**WEST SUSSEX COUNTY COUNCIL
STRATEGIC PLANNING CONSULTATION**

**SUBJECT: LU/182/14/PD - Prior notification under Class 1A for change of use from
A1/A2 (retail/financial & professional services) to C3 (dwellinghouses)**

1 & 2 Norfolk House, Wick Street, Littlehampton, West Sussex, BN17 7JR

1:200 BLOCK PLAN

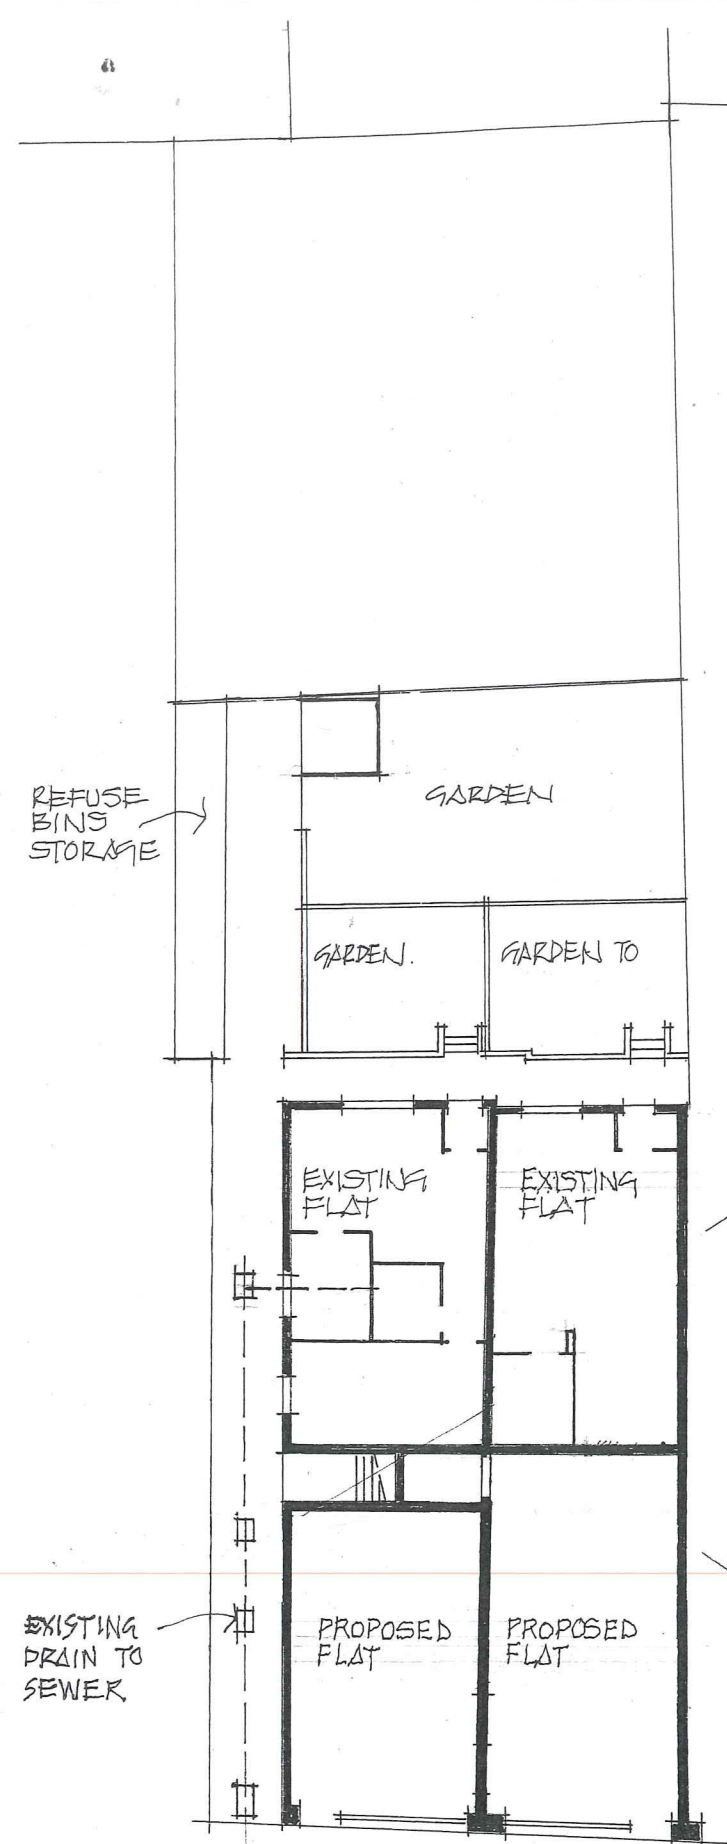
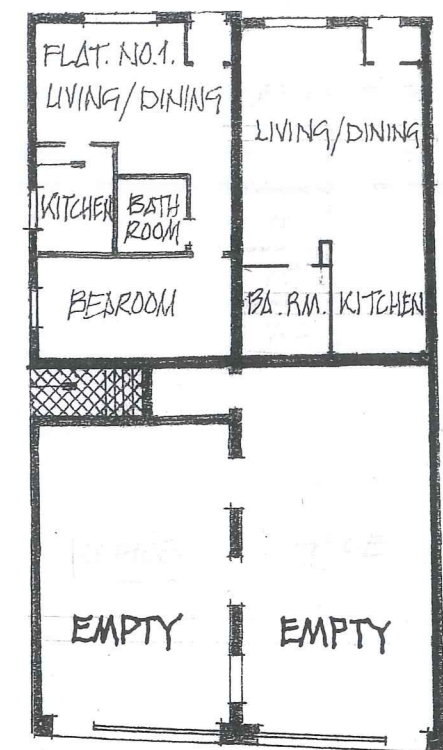
The proposal is for the prior notification of an existing A1/A2 unit into 2 residential units with access onto Wick Street via an existing access point. From an inspection of the plans alone, there is no apparent visibility issue at the point of access onto Wick Street.
